Morris Goding  
Access Consulting

2 Mandala Parade Doran  
Drive, Doran Drive, Castle Hill  
NSW – Supermarket Fit-Out

**Access Review –  
Final**

5 July 2021

GROUND LEVEL PLAN
PROPOSED RETAIL & COMMERCIAL
DORAN DRIVE PRECINCT
DORAN DRIVE, CASTLE HILL NSW 2154
FOR DEICORP PROJECTS (SHOWGROUND) PTY LTD
21015 SK 1.04 H

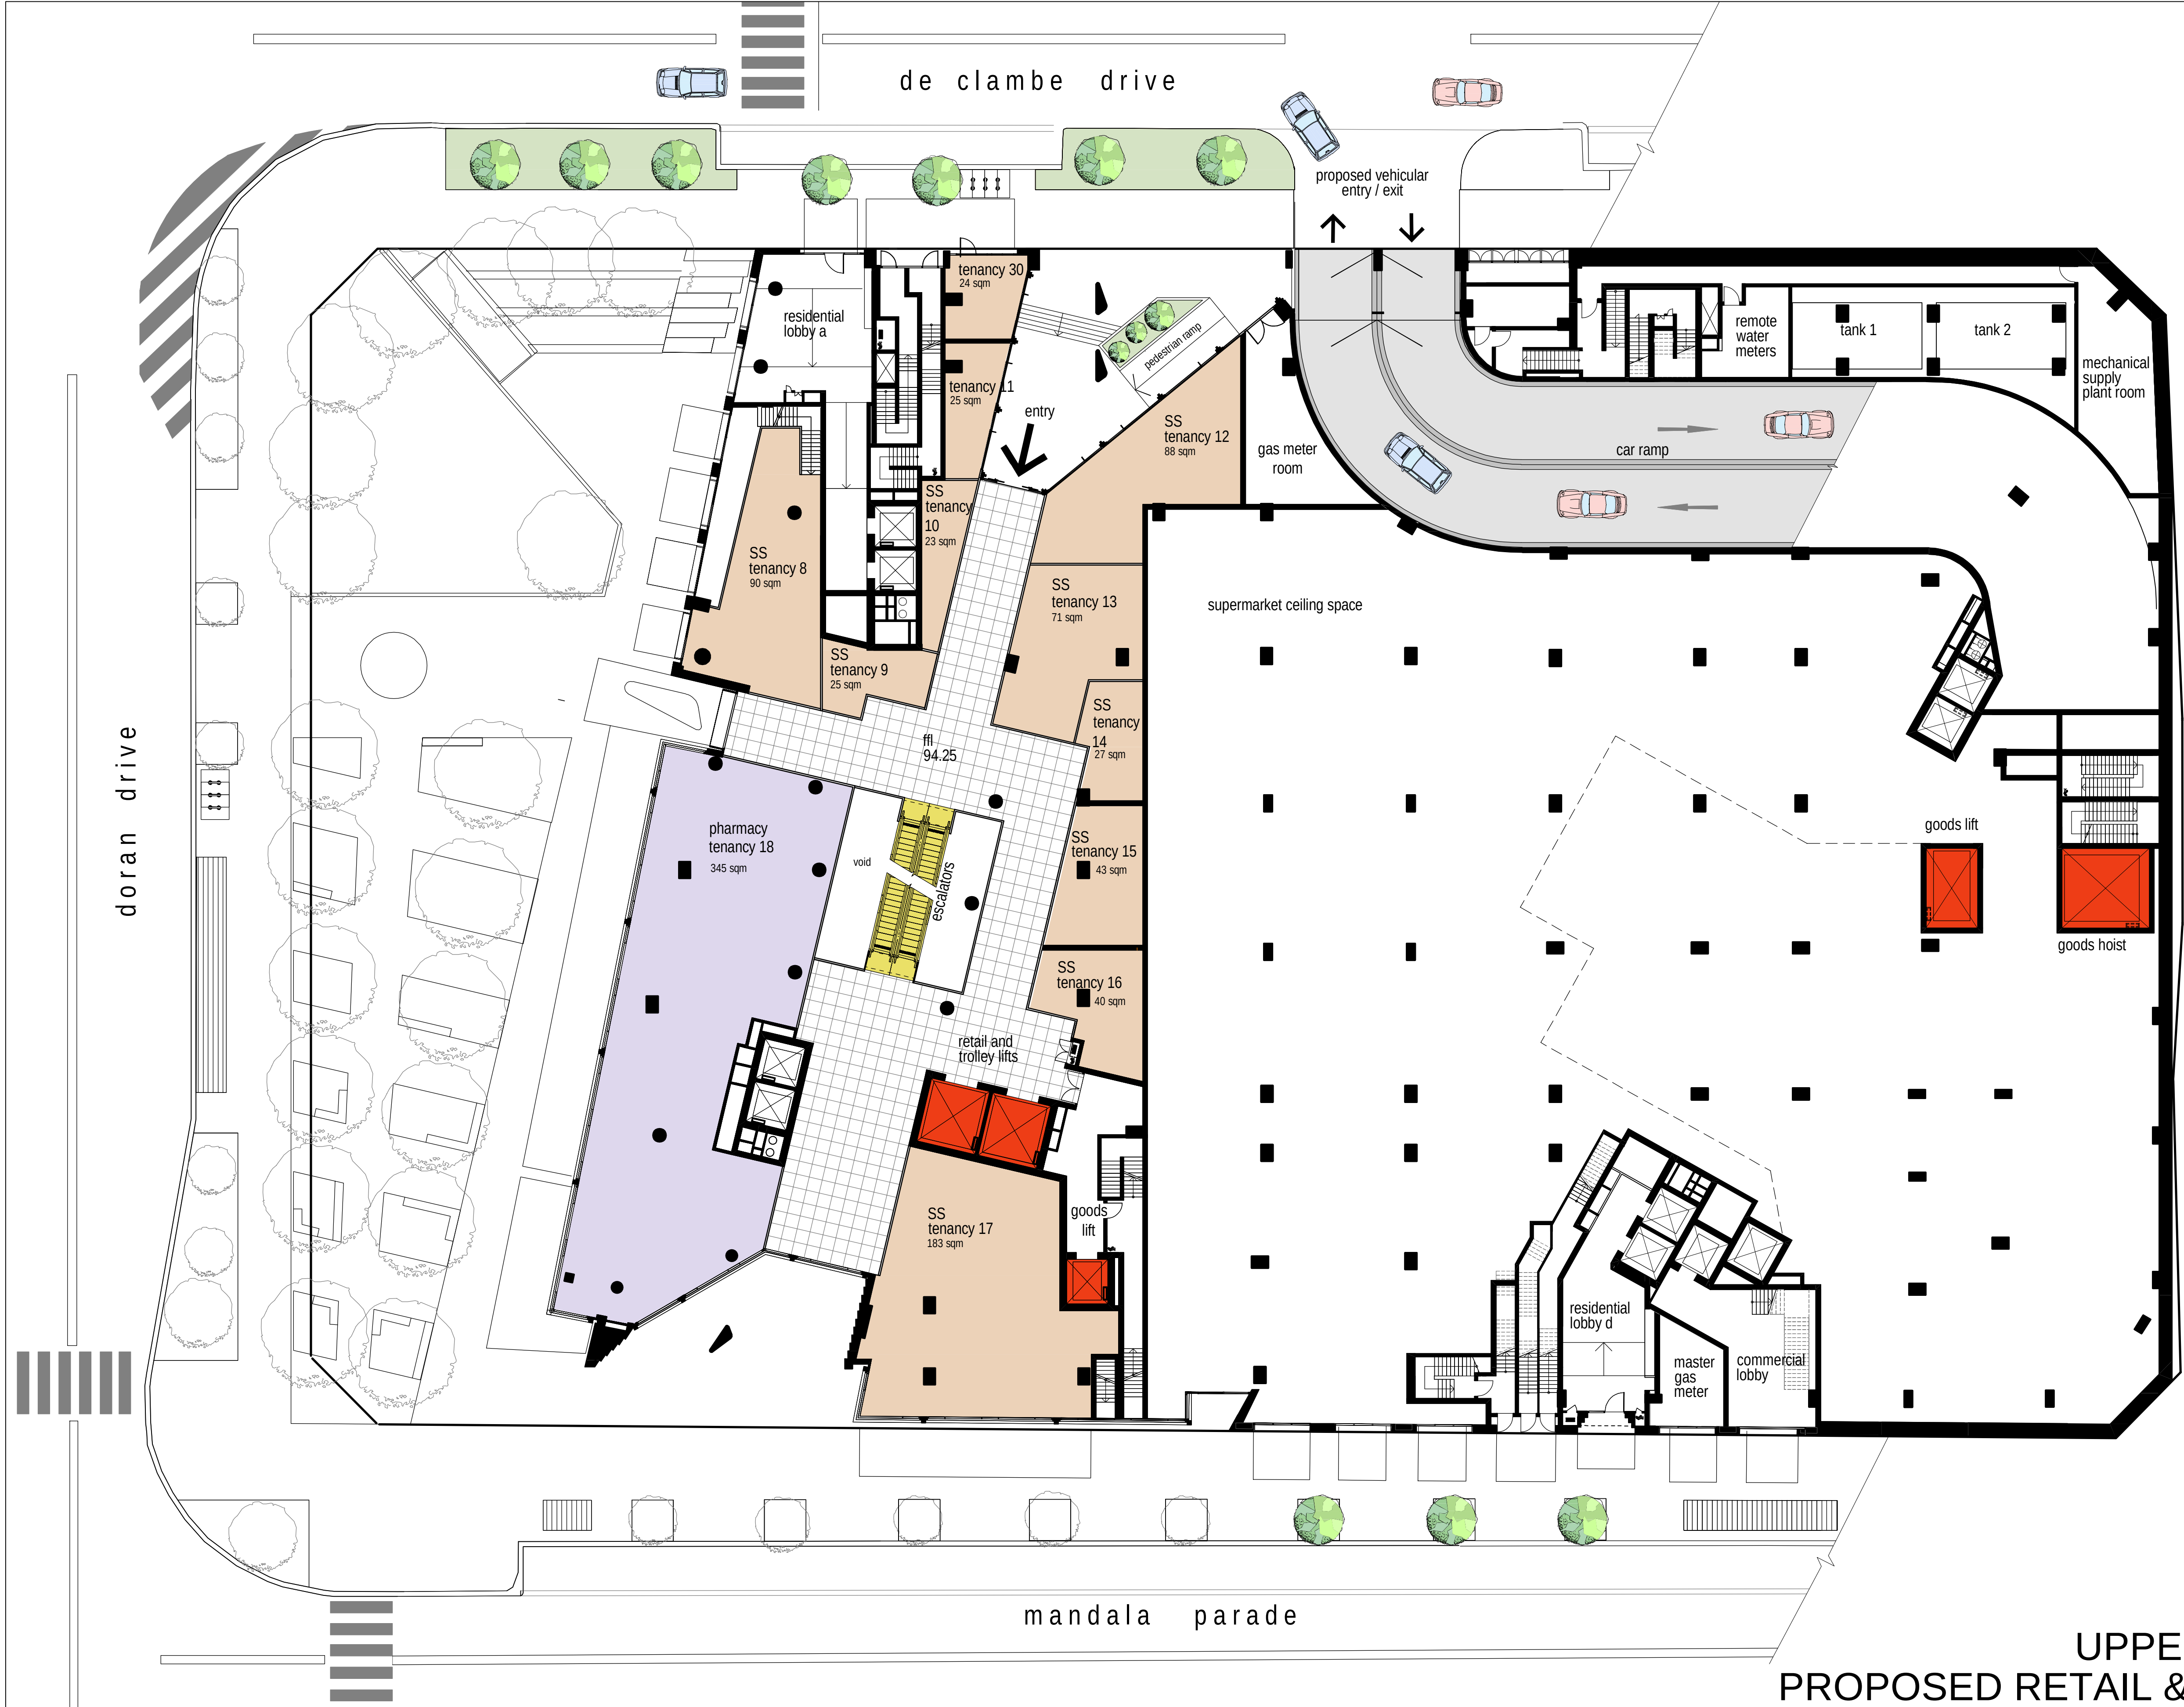
- Turning spaces (at least 1540mm W x 2070mm L) are required within 2m of every corridor end and at 20m.max intervals along all access-ways. This is needed for wheelchairs to make a 180 degree turn, compliant with AS1428.1:2009. Currently this requirement is not achieved as there is lack suitable circulation at the end of the corridor in the amenities. There is sufficient space for amendments to be made to readily achieve compliance during a further stage.

- All common-use doors (ie. not excluded under Part D3.4) to have 850mm min. clear width opening (each active door leaf) and suitable door circulation area, compliant with AS1428.1:2009. Currently requirement appears capable of being achieved, however, liquor cool room and service desk have a deficient latch side clearance and clear width. Doors are to provide 530mm min.(internal). And 510mm min. (external) latch side clearance or door is to be automated or client is to confirm that this area is indented to be exempted under BCA D3.4. This can be address during a later stage.

- Accessible WC requires 2300mm x 1900mm around the pan with the basin to sit outside this area in accordance with AS1428.1.
- An ambulant cubicle is required within every standard toilet bank adjacent to an accessible toilet under DDA Access Code Part F2.4 compliant with AS1428.1:2009. Currently requirement appears capable of being achieved for male. However, the female circulation space is deficient. Provide 900mm x 900mm clear circulation space at the entry door. refer to AS1428.1, Fig. 53(B). There is sufficient space for amendments to be made to basins bench to readily achieve compliance during a further stage.

MGAC has reviewed the drawings and documentation in relation to the aforementioned requirements. On the basis of the current level of detail all access requirements appear capable of achieving compliance subject to resolution of some minor issues in regard to lack of suitable door width circulation for the service desk. Ensure 850mm min. clear door circulations is provided or client is to confirm that this area will apply D3.4 exemption due to duties to be performed by staff members. This can be address during a later stage.
